From: Simon Davis
Sent: 22 December 2017 09:59
To: Planning.Responses
Subject: FW: 36 Corbishley Rd BR/289/17/DOC

From: T [REDACTED]
Sent: 21 December 2017 17:16
To: Simon Davis
Subject: 36 Corbishley Rd

Site Plan: Scale 1:200

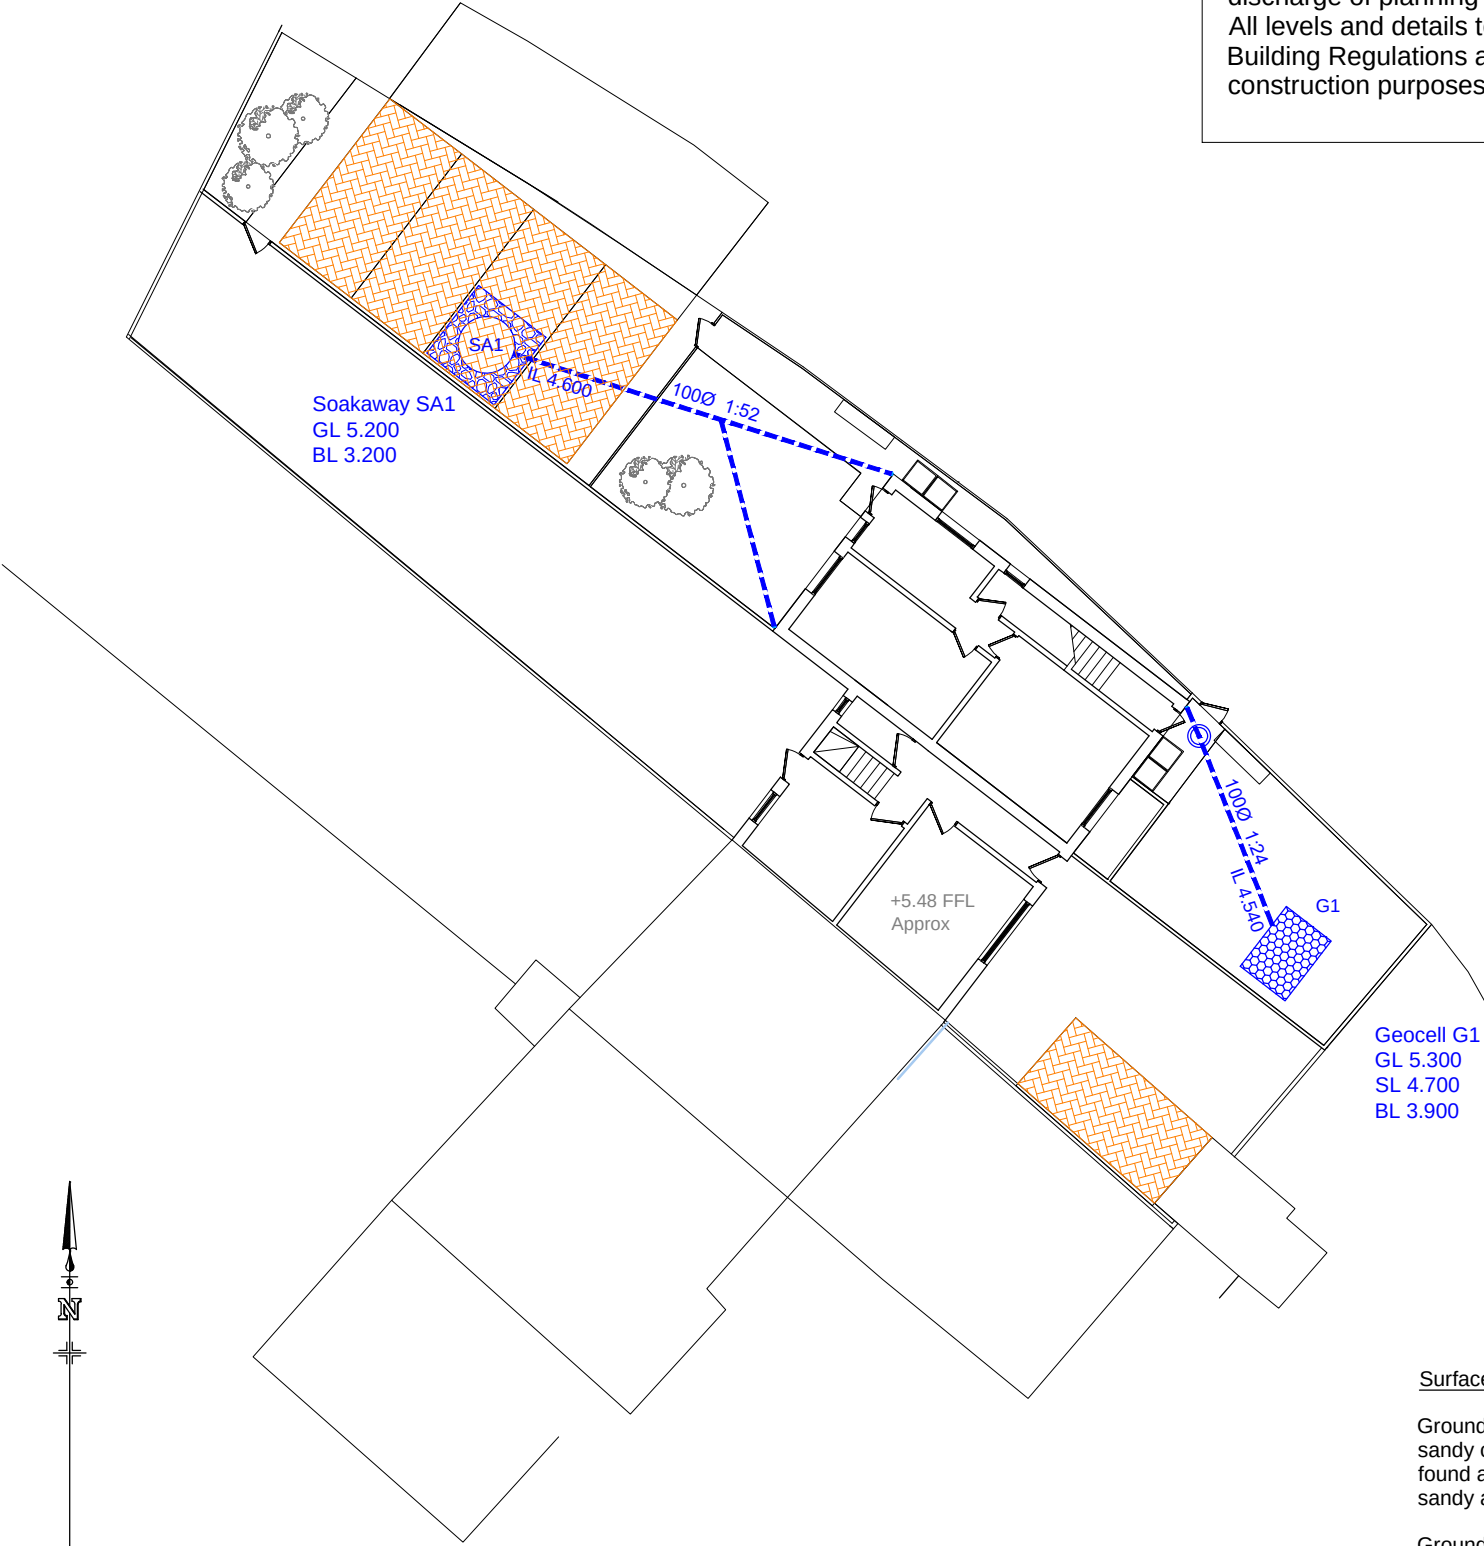
1. It is normally good practice to have a silt trap upstream of any soakaway structure, as it is easier to clean out a manhole sump, than the soakaway itself. Provided the applicant undertakes regular maintenance on the soakaway, then fine, omit the manhole silt trap.
2. Noted that there is no interaction between the permeable pavement and soakaway, however, construction details are required for the permeable paving.

1. Provide silt trap manhole upstream of PCC ring soakaway.
We do not normally add silt trap manholes upstream of concrete ring soakaways as the soakaways themselves act as silt traps and can be cleaned out either manually or by tanker. The calculations do not include for soakage to occur through the base – only the sides for this reason.

Typical Permeable Paving
Scale 1:20

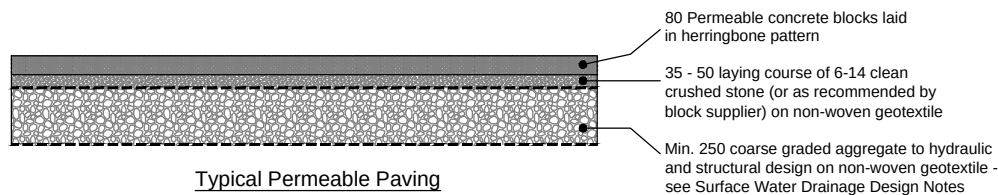
2. Provide construction detail to show how permeable pavement construction interacts with PCC ring soakaway.
The concrete ring soakaway is not designed to interact with the permeable paving in this case as it can deal with the flow on its own without the assistance of the permeable paving.

3. Provide construction detail/calculations for the standalone section of permeable paving.
The standalone permeable paving just needs to deal with rainfall that lands on it – it is not required to accept flow from other impermeable areas and as such, is an improvement on original soft landscaped areas.
